TRI-LAKES MONUMENT FIRE PROTECTION DISTRICT

Subject: Grandwood Ranch

Date: June 15, 2020

Based upon your email below are our responses to the two questions posed by El Paso County.

GRANDWOOD RANCH			
PRELIMINARY PLAN - PCD FILE NO SP195			
PLAN SHEET			
DESIGNED BY: CAP	SCALE: HORIZ 1"=100'	DATE ISSUED: JUNE 2020	DRAWING No. PP 01
DRAWN BY: CAP	VERT.	SHEET 3 OF 6	
CHECKED BY: JA

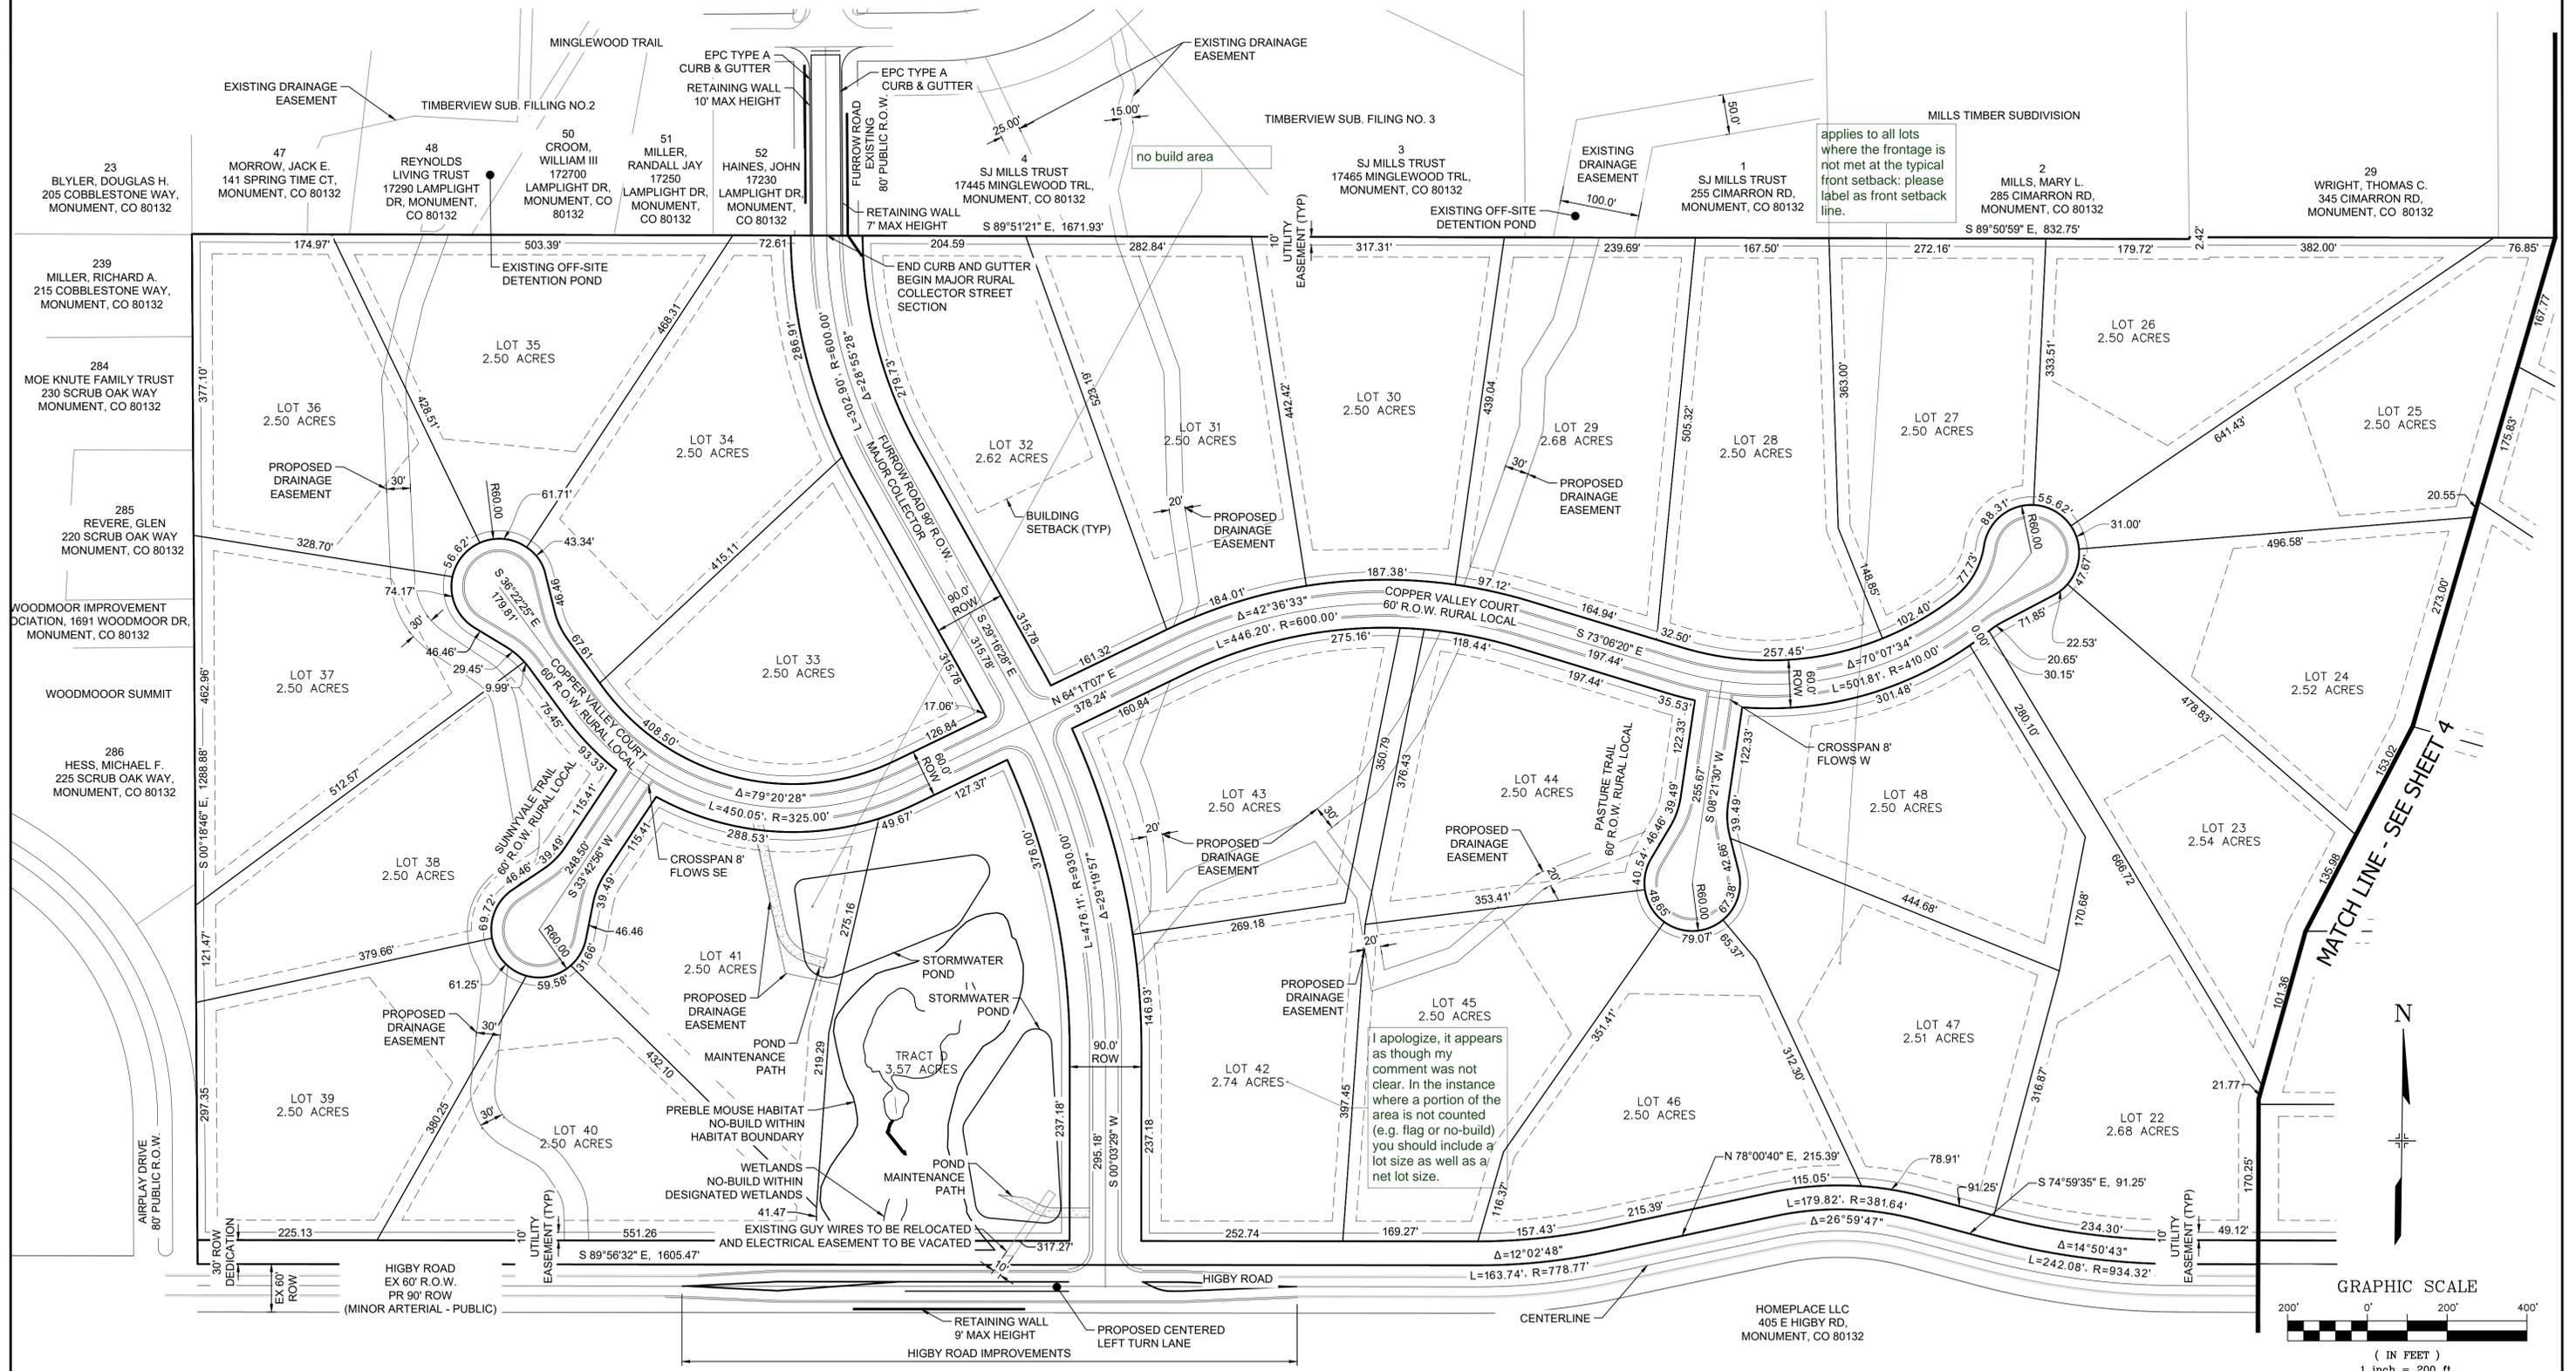
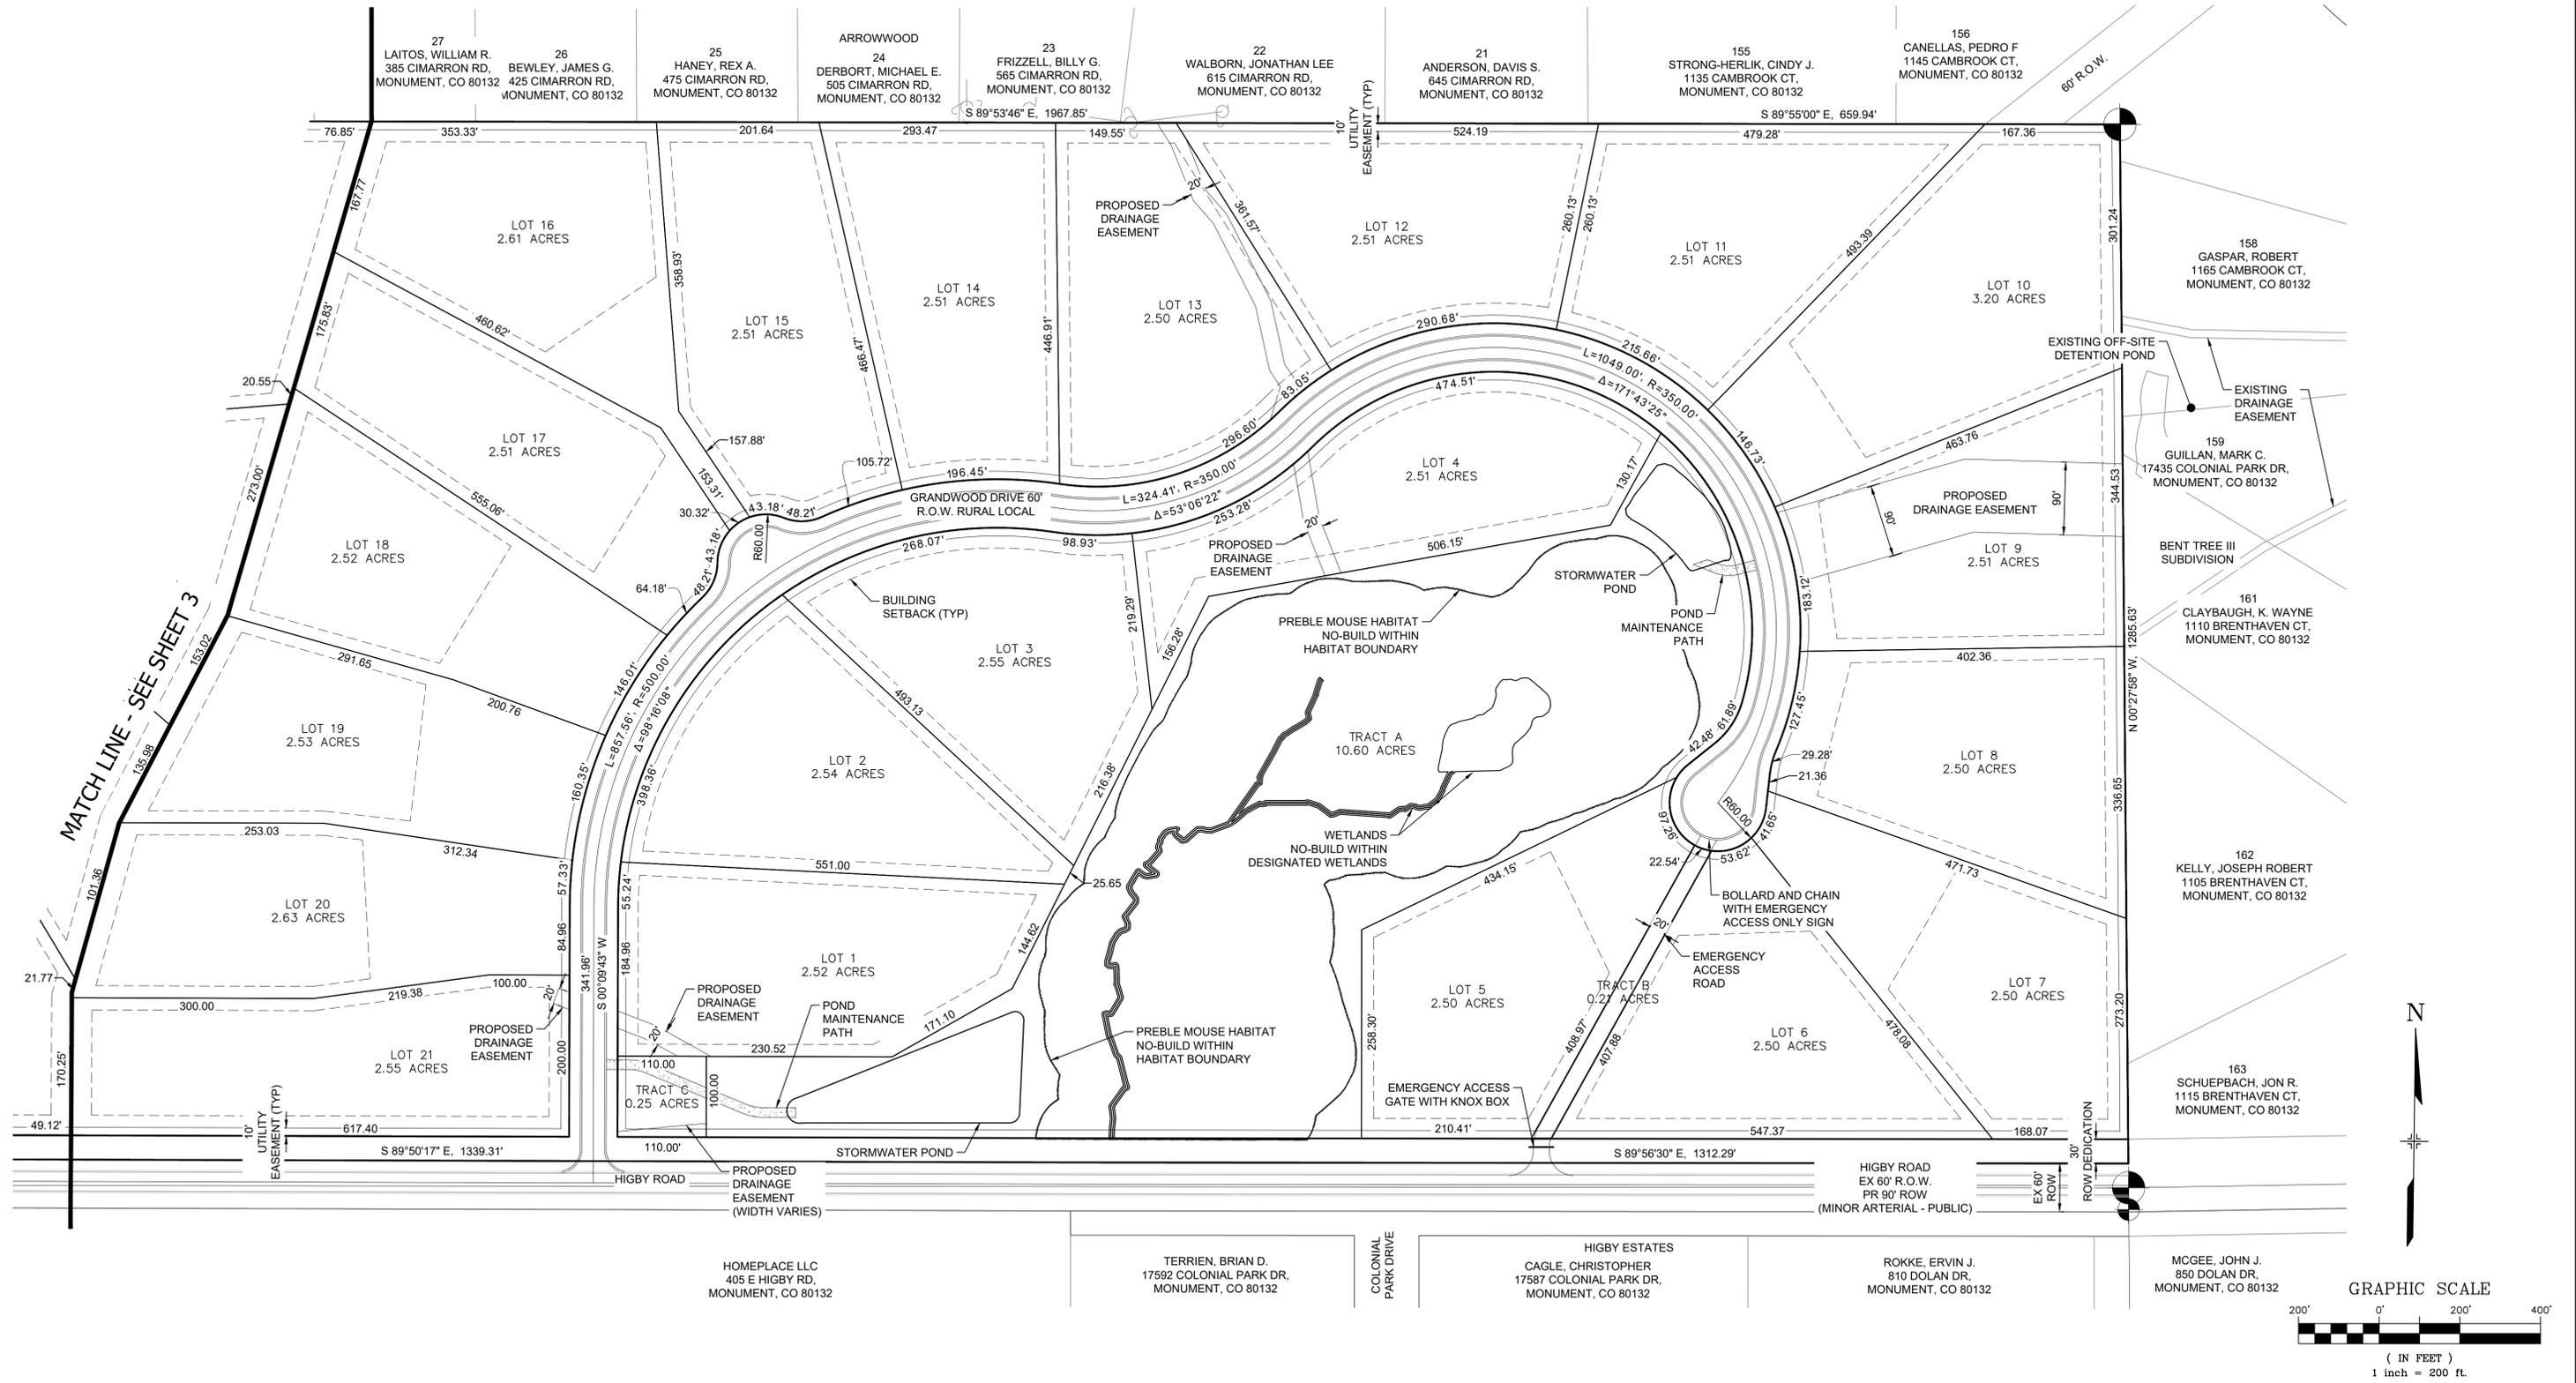
Question #2: Emergency Access Gates

We agree with the County's request to have a gate installed ta Highby Road with a Knox Access for our crews and other responders. As to requiring a gate at the Grandwood Drive end, I am ok with allowing the developer to determine if they want a gate, chain, or nothing. If there are gates or chains, we will require Knox access to that as well.
